Application for a Non-Material Amendment Following a Grant of Planning Permission

Proposed Two Storey side extension and Rear Extension

HOU/2022/0011

AL/01 Dwg 03E

PROPOSED PLANS AND ELEVATIONS

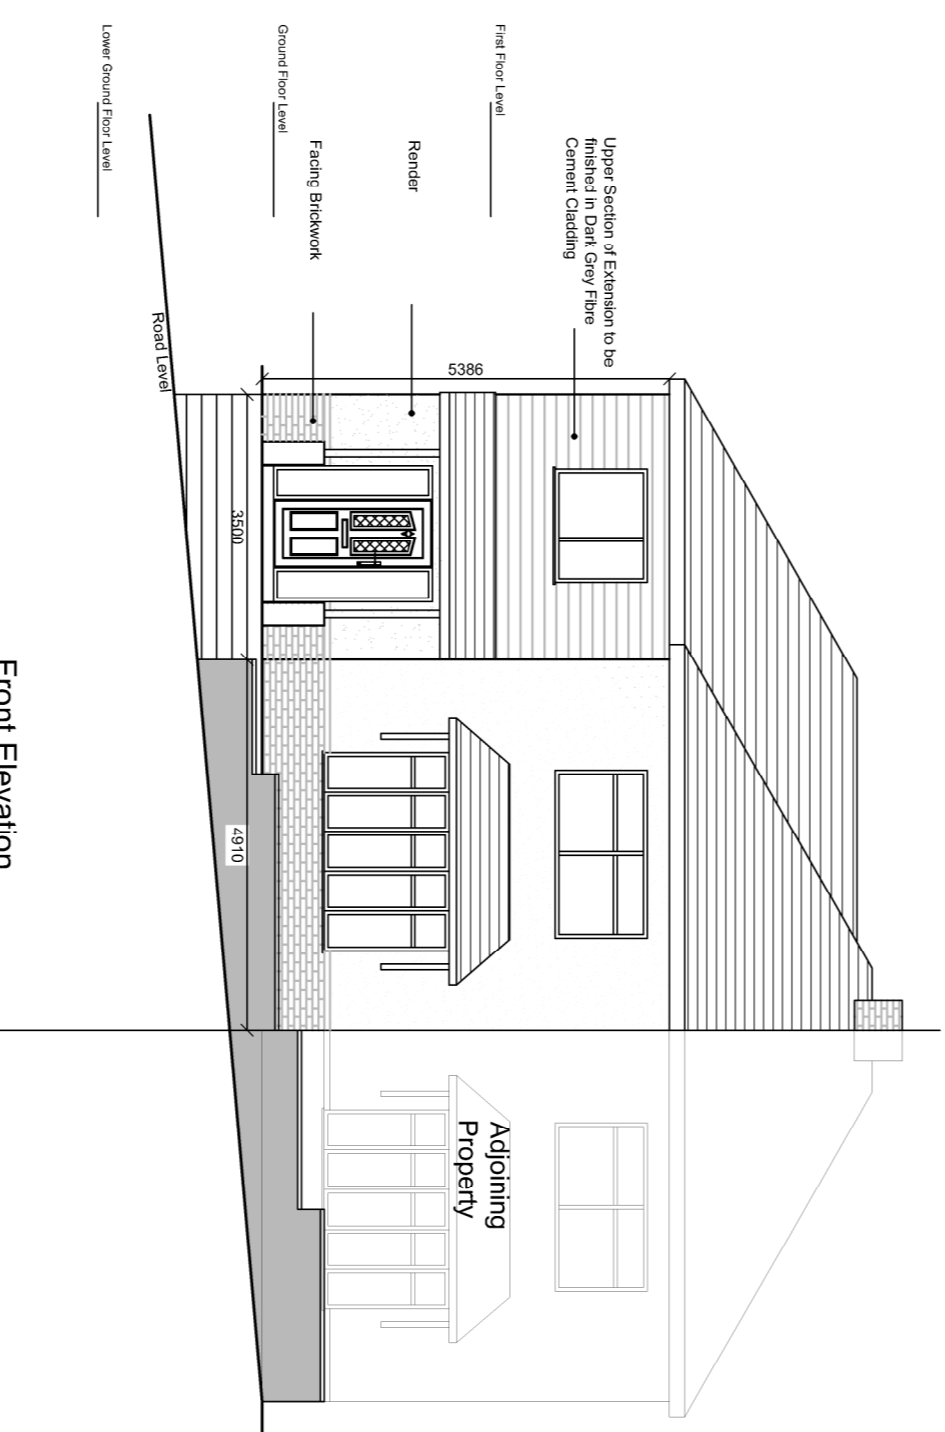
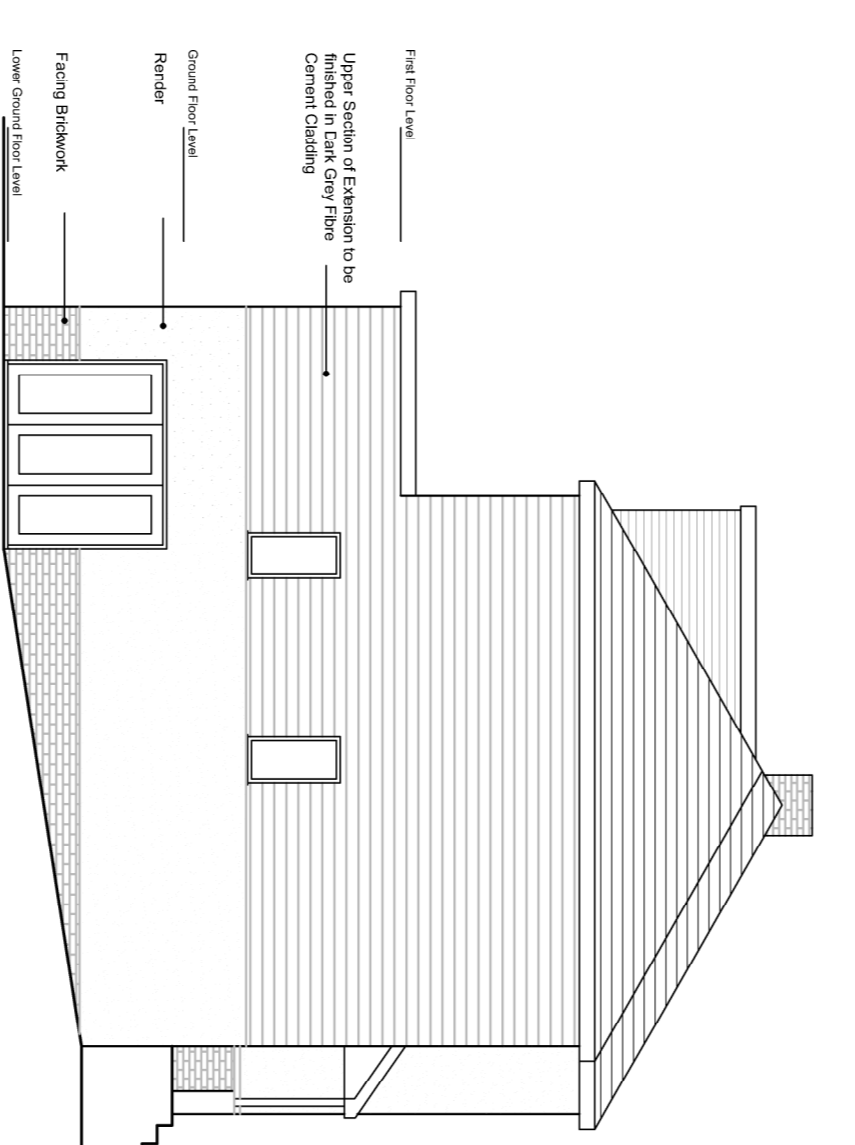
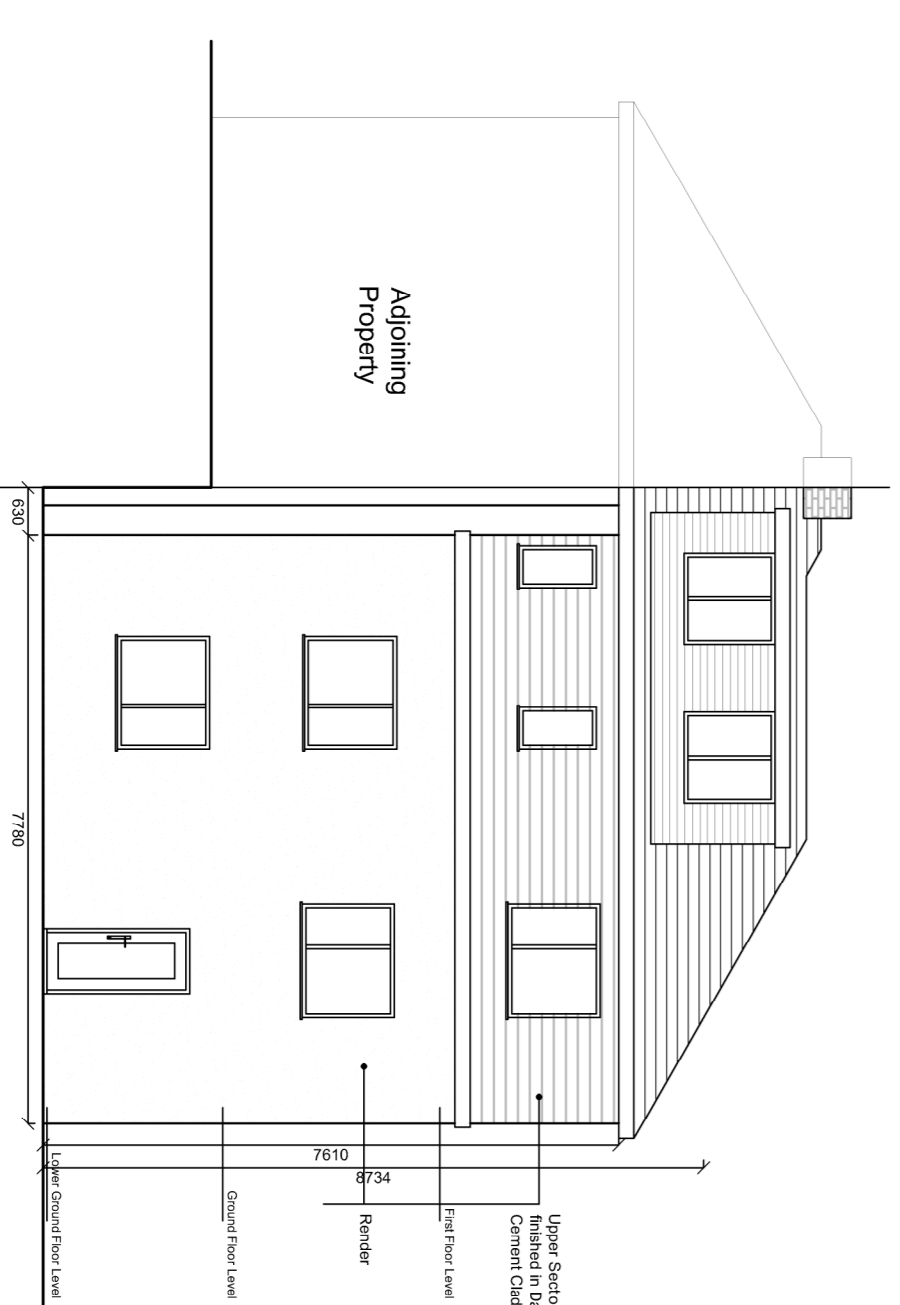
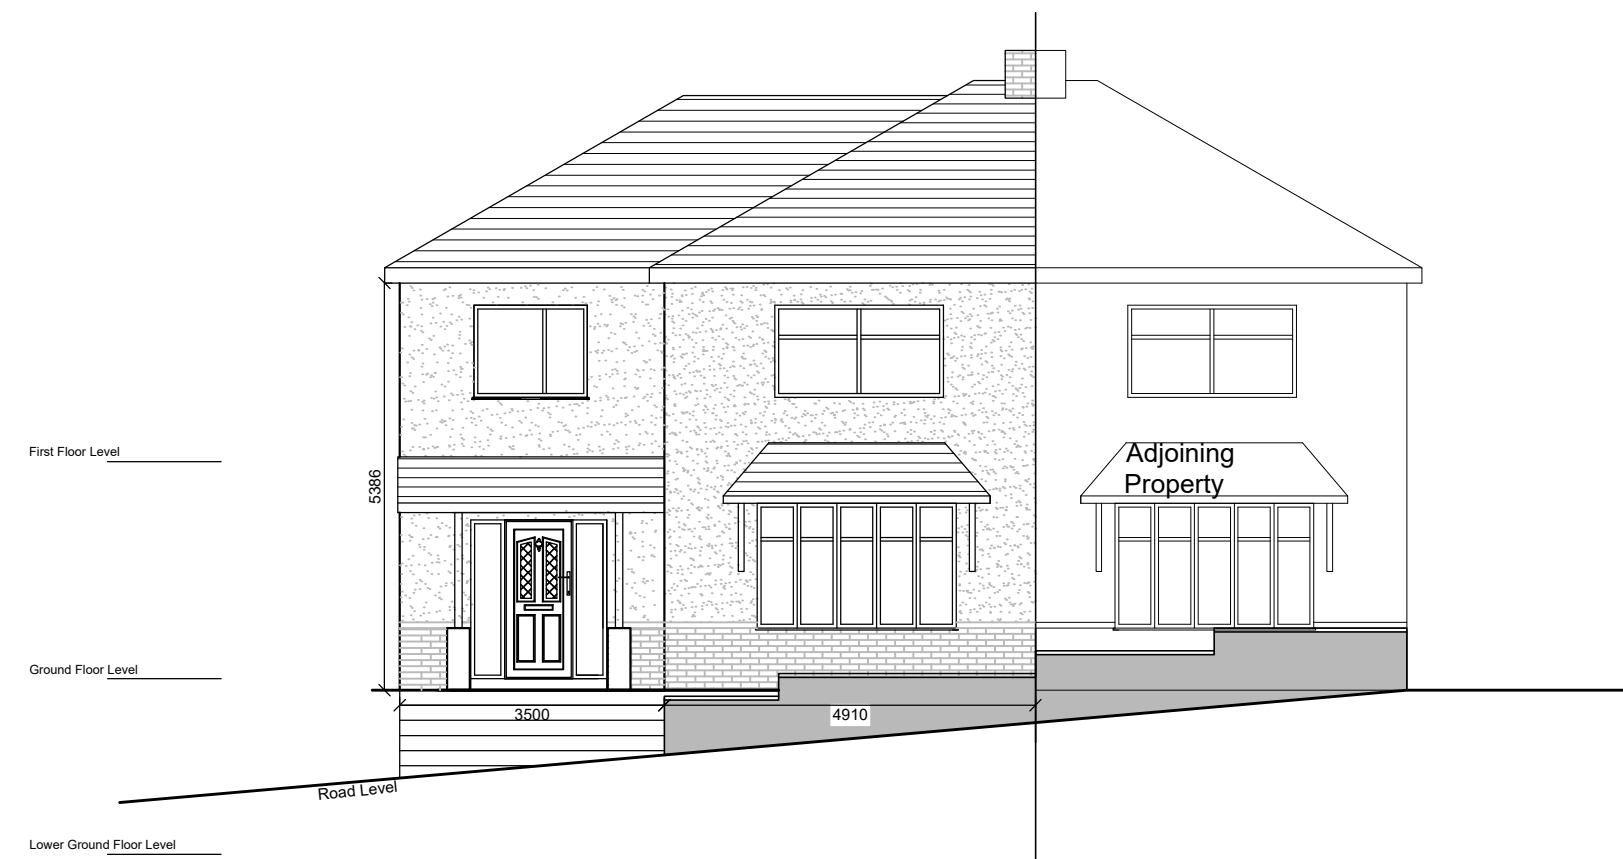
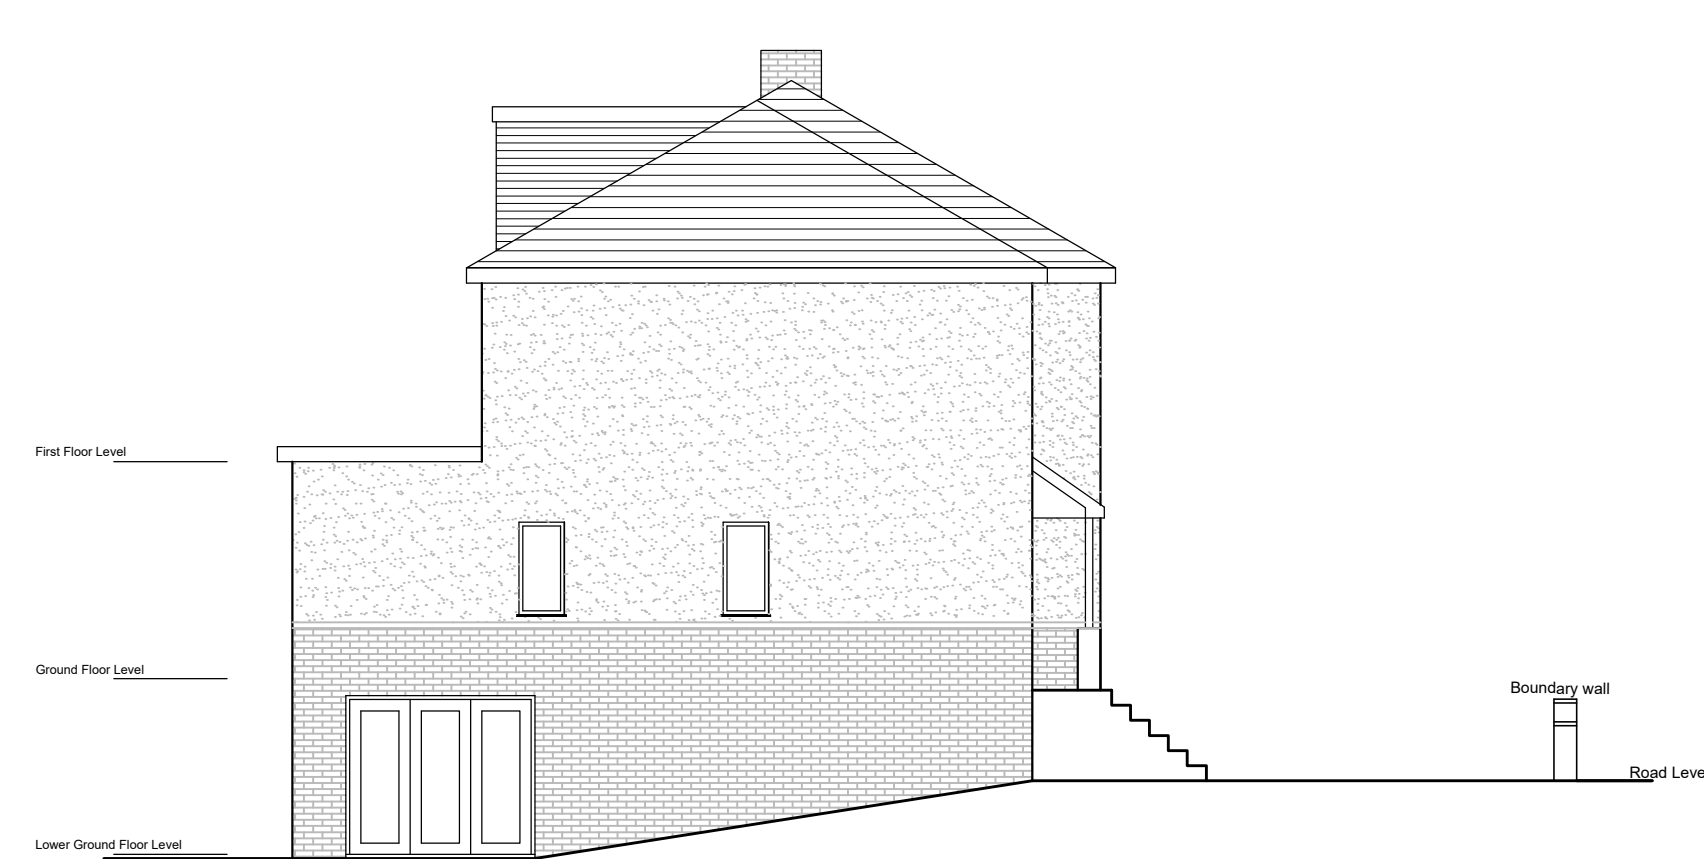
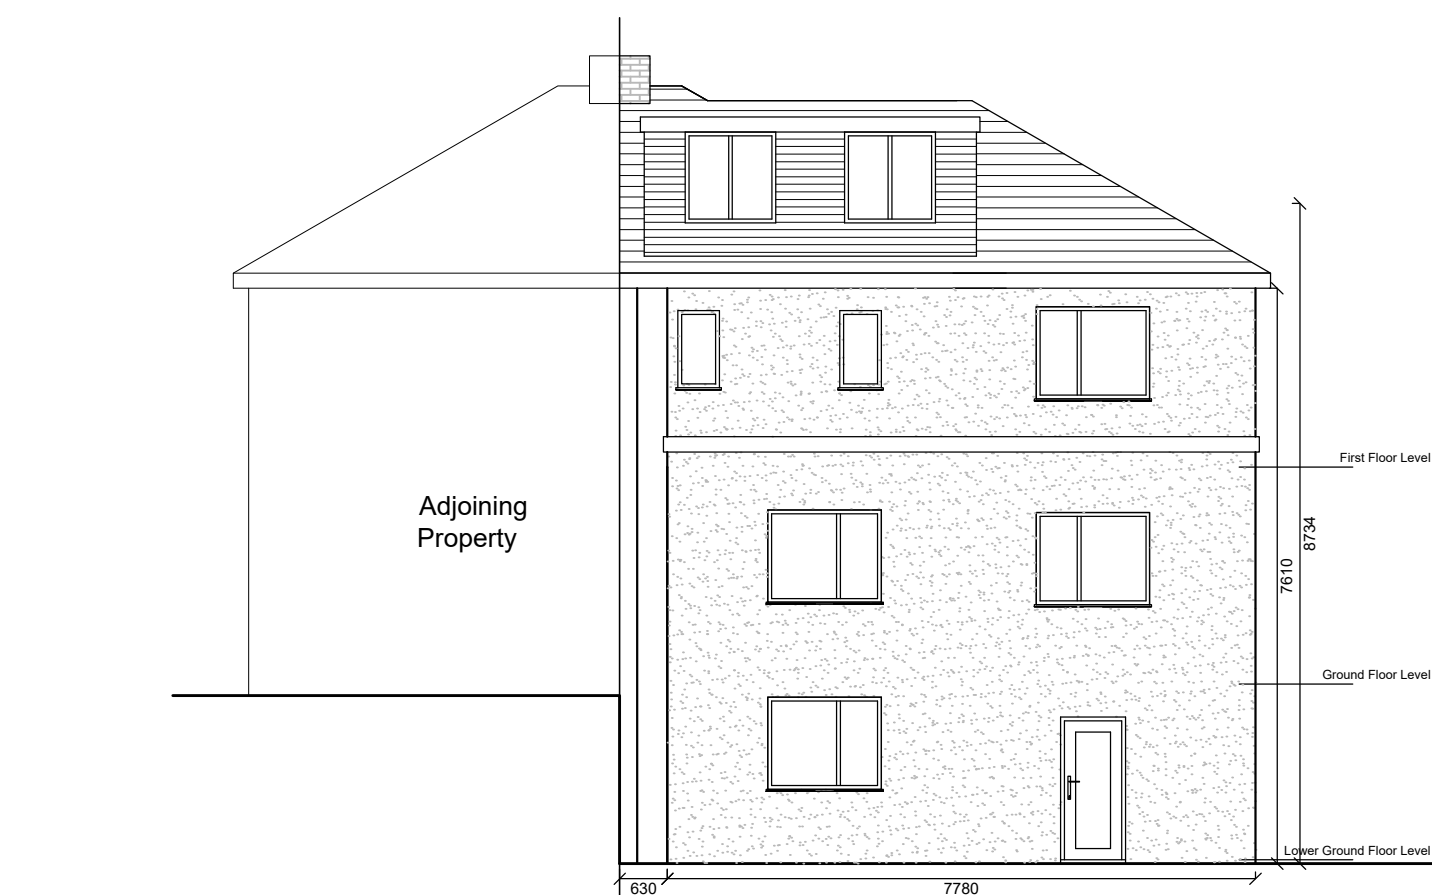
We are wanting to change some of the external facing materials to the external walls that were approved.

The dwelling where located gets exposed to strong wind and rain and the building contractor working on the job has recommended that render to the external walls would not have a long life expectancy and would require repairs carried out on a regular basis. The client has seen the fibre cement board on other new build developments in the area, carried out research and seen that they can be maintenance for up to 20 years, therefore a better alternative to a render finish
